ARBORIST Memo

Report Date:
March 3, 2024

Site Address:
3036 67th Avenue SE
Mercer Island, WA

I visited the February 29, 2024 to re-assess Tree #2, after invasive ivy was removed, together with a further assessment of Tree #3, in light of comments from City arborist John Kenney and from neighboring property owners.

LEGEND

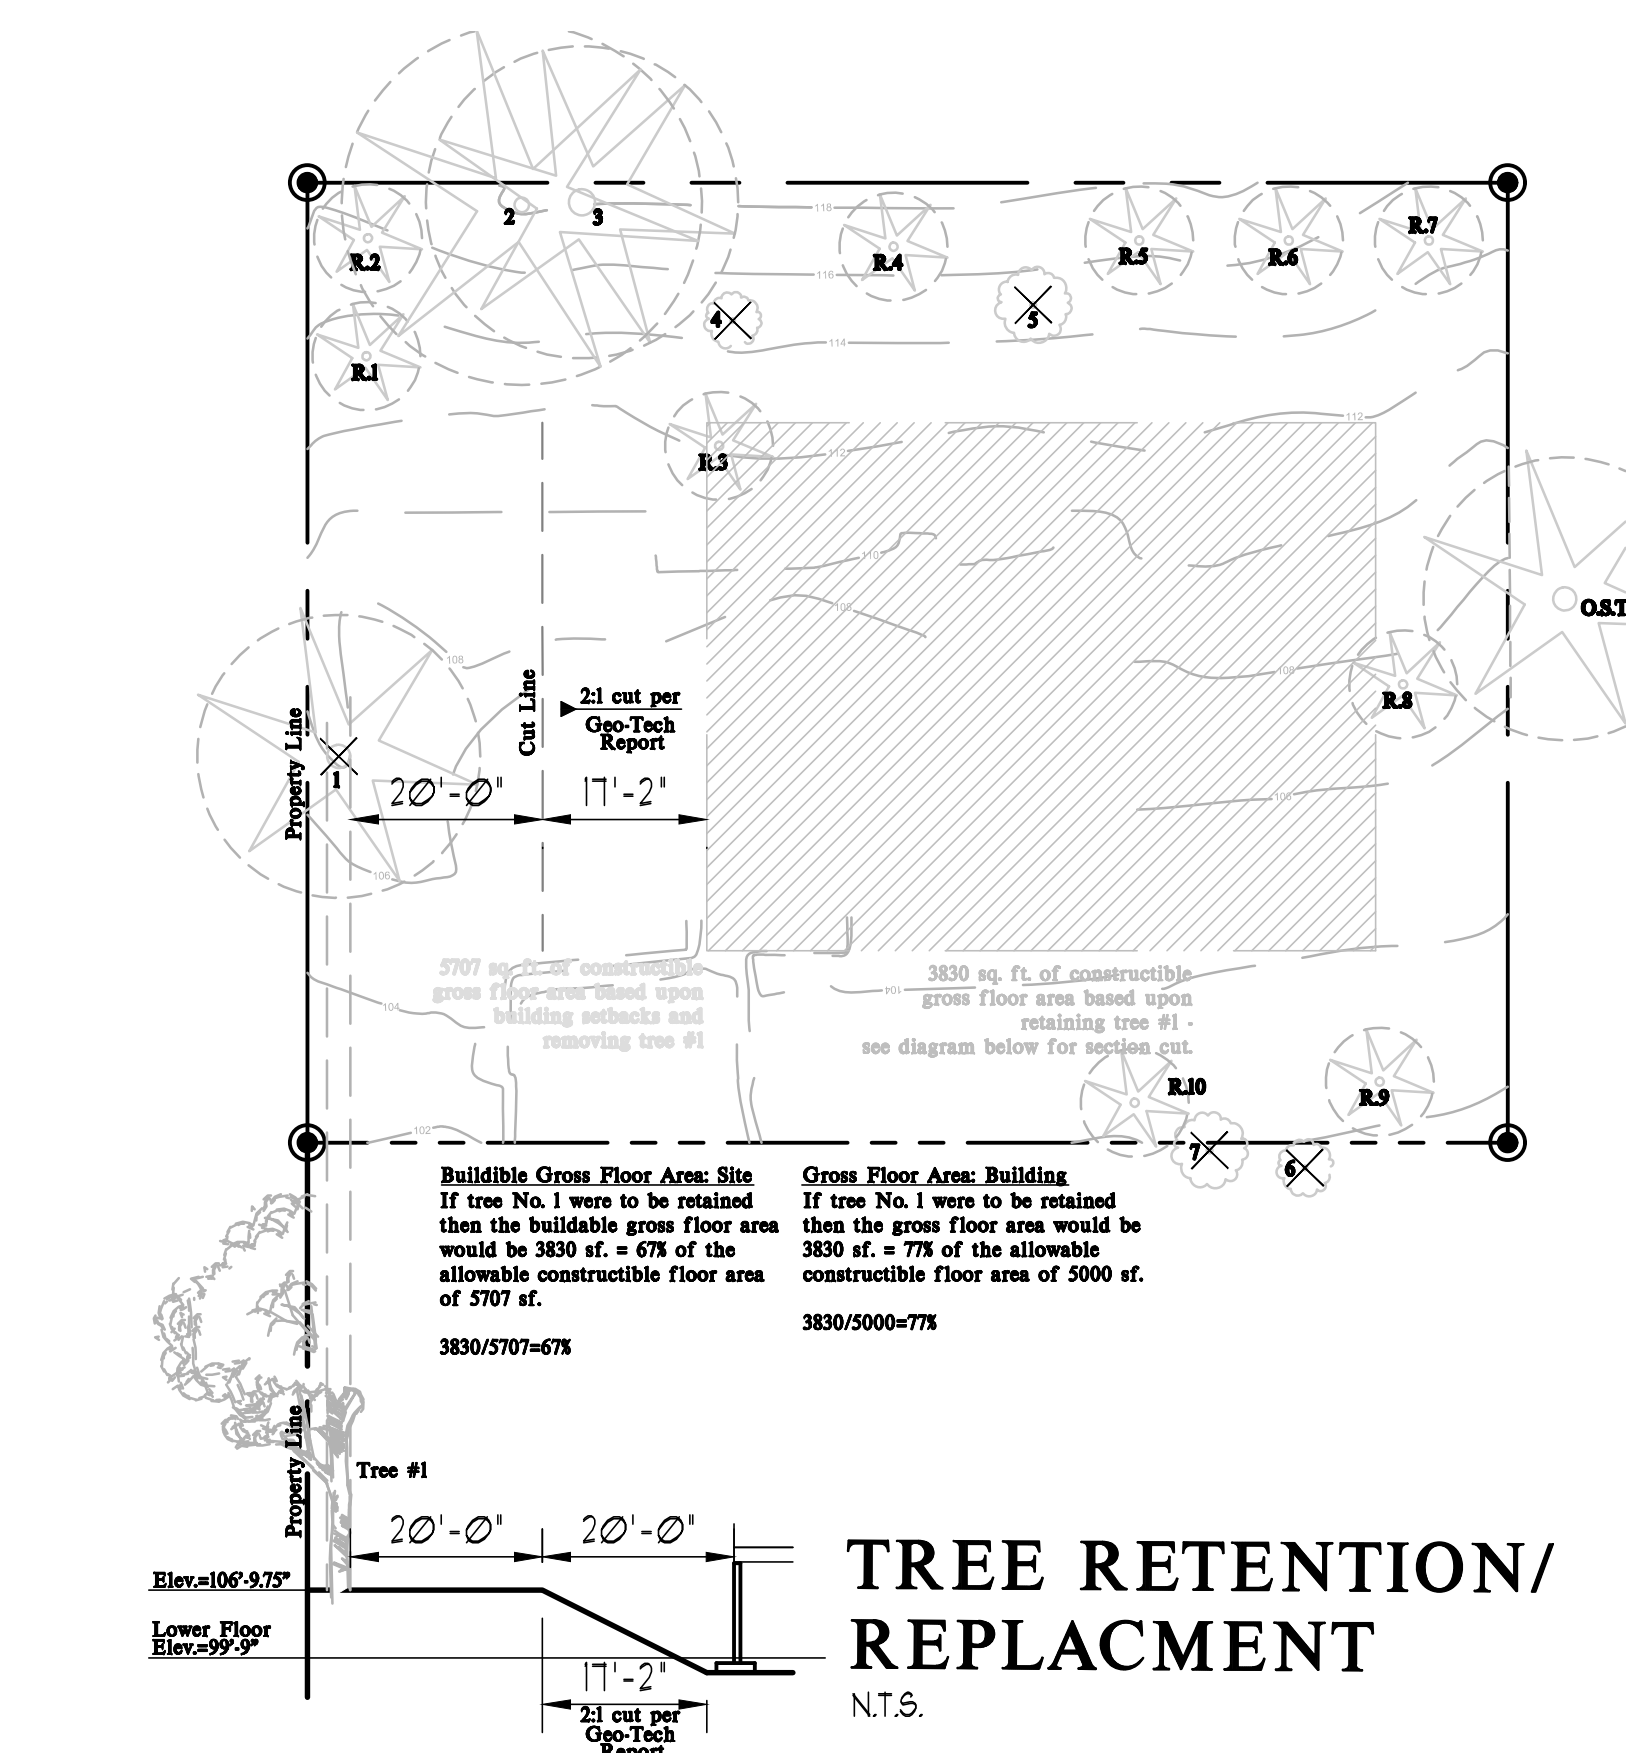
City arborist John Kenney also indicated that I should suggest an alternate species to the planned planting of Western Red Cedar trees in the backyard of the subject property. I have reviewed plan sheet A1.1 and agree that replacing four(4) of the four Western Red Cedar trees with Vine maple will make for happier uphill neighbors and will provide a better planting pallet, long-term.
